Subject: WA/123/21/DOC-Land Adjacent 1 Orchard Way Fontwell Arundel BN18 0SH

Engineers Comments Regarding Condition 15

UNIT ONE + TWO

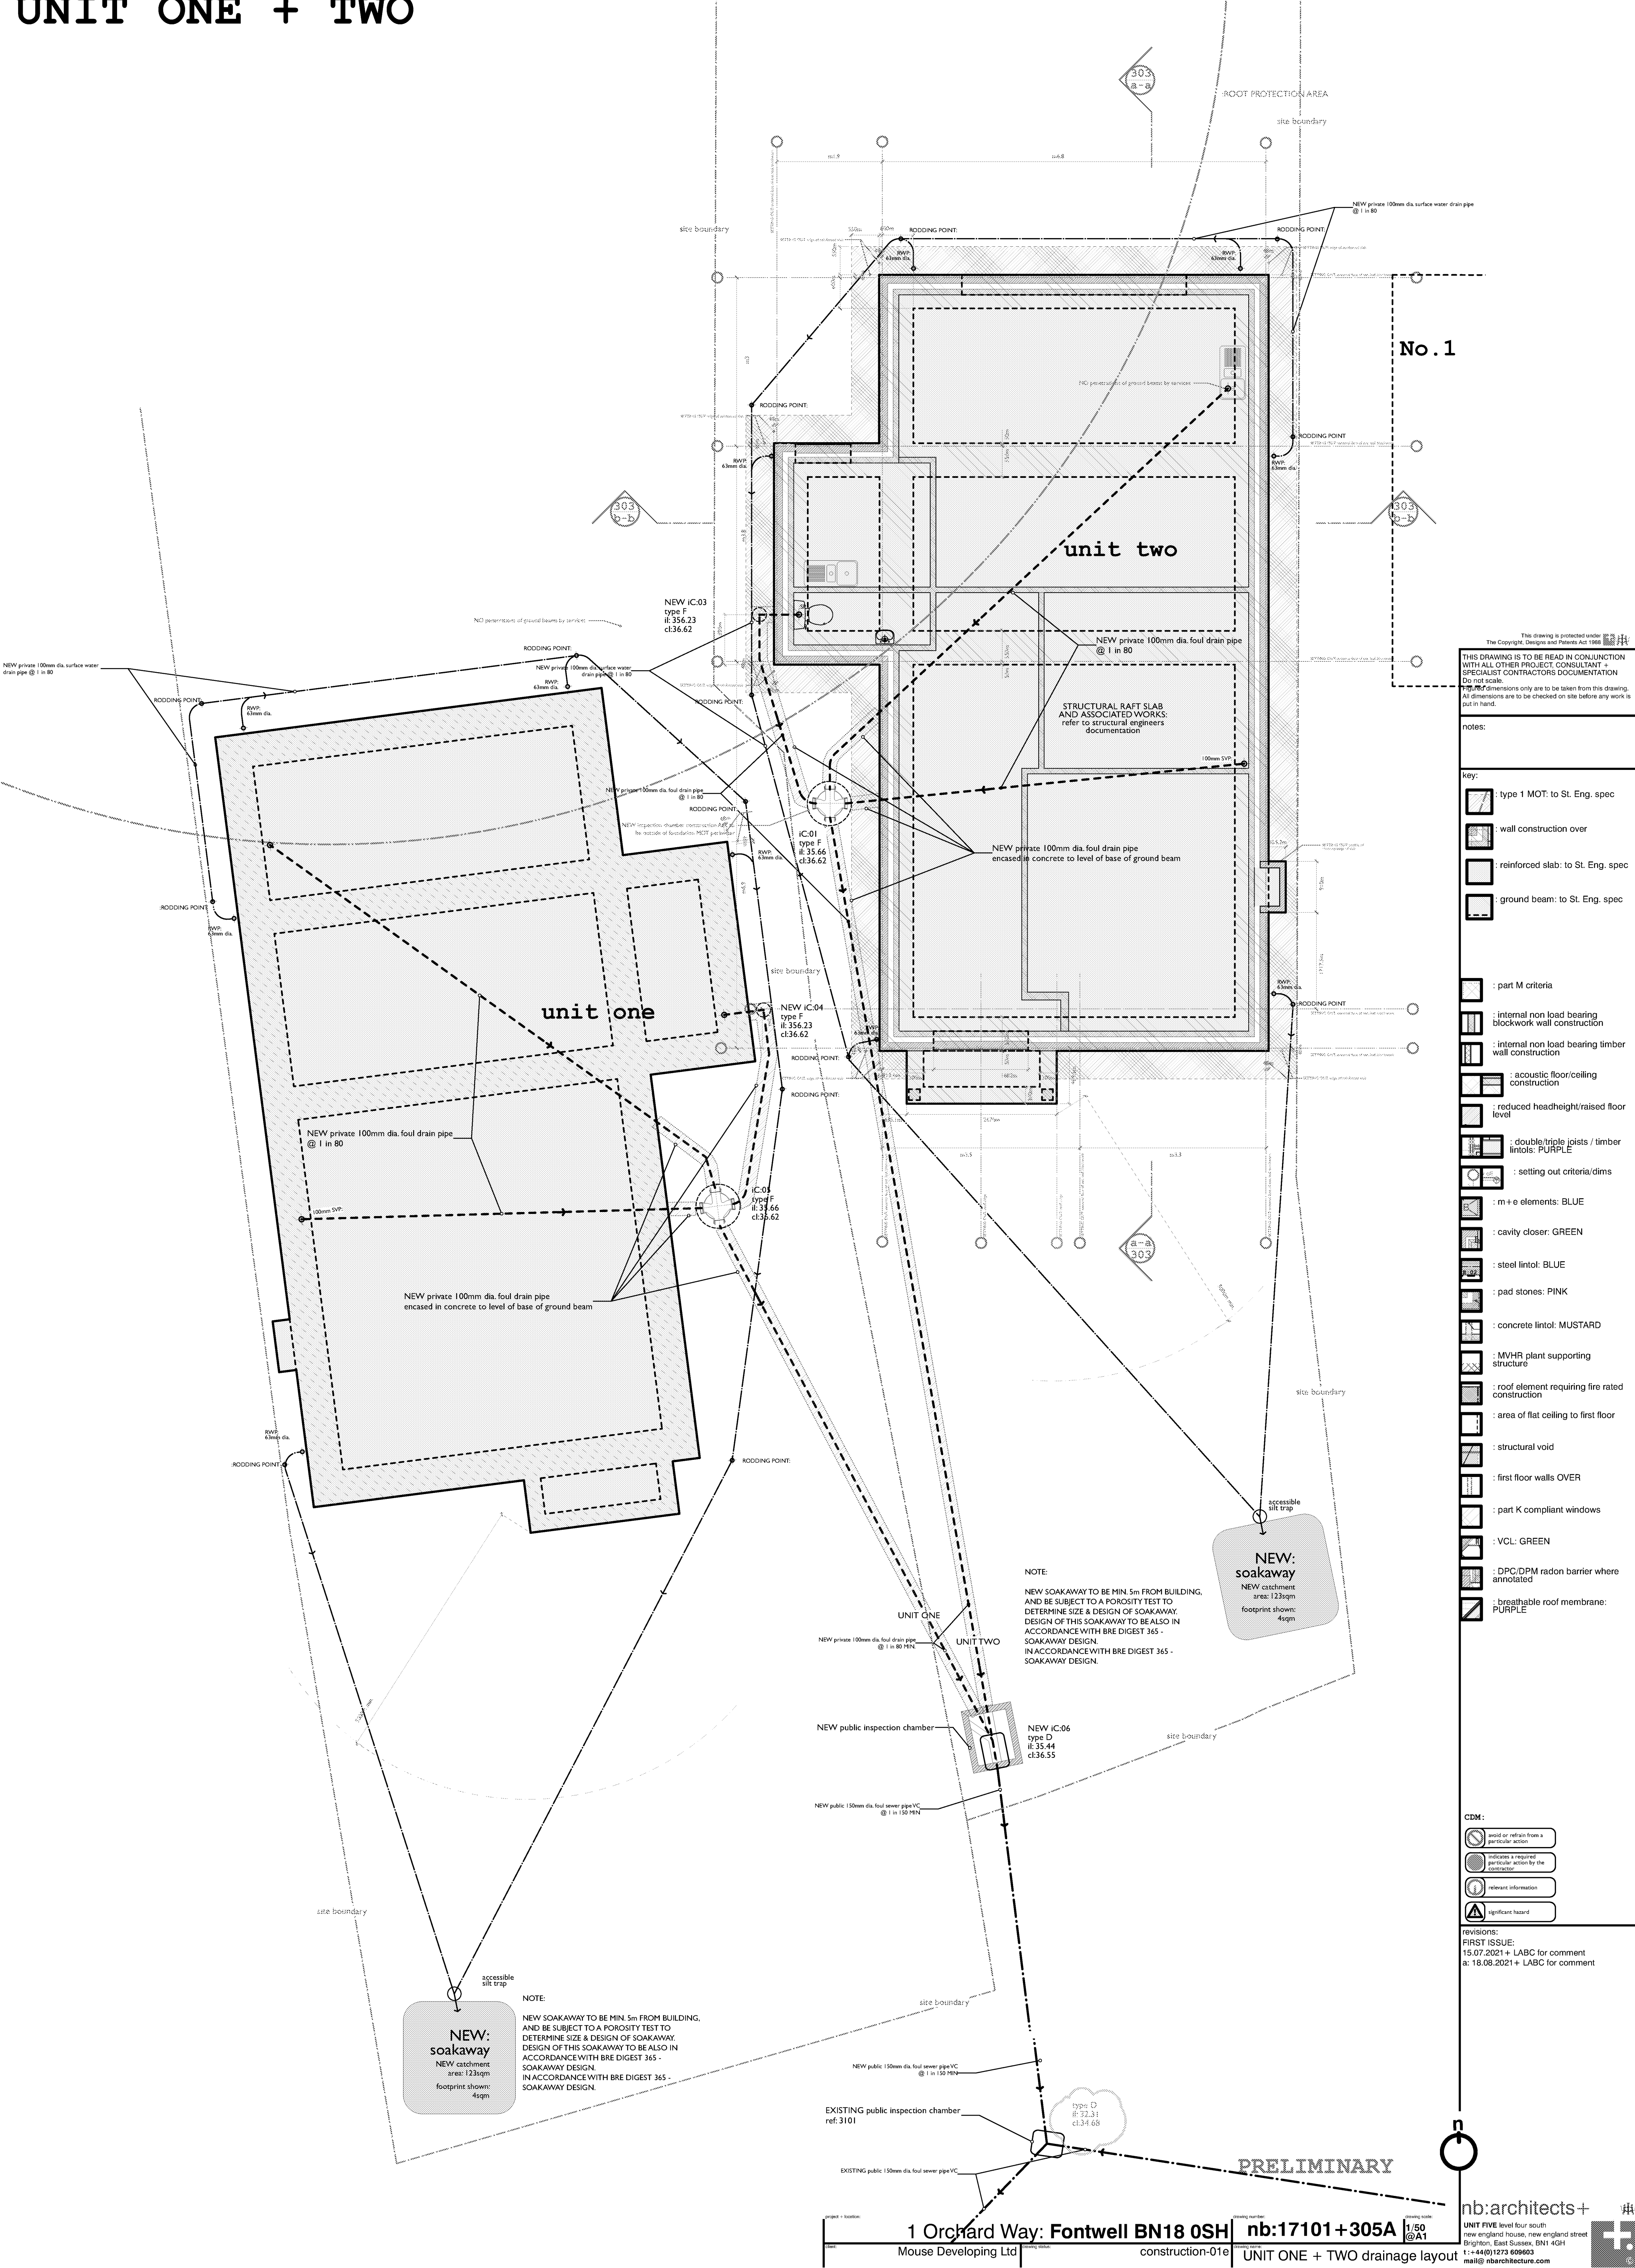
Please ensure that the drainage plans are not listed as approved under this condition. These need to be approved under Condition 17, I understand that when we were consulted on this previously that we had a number of comments.
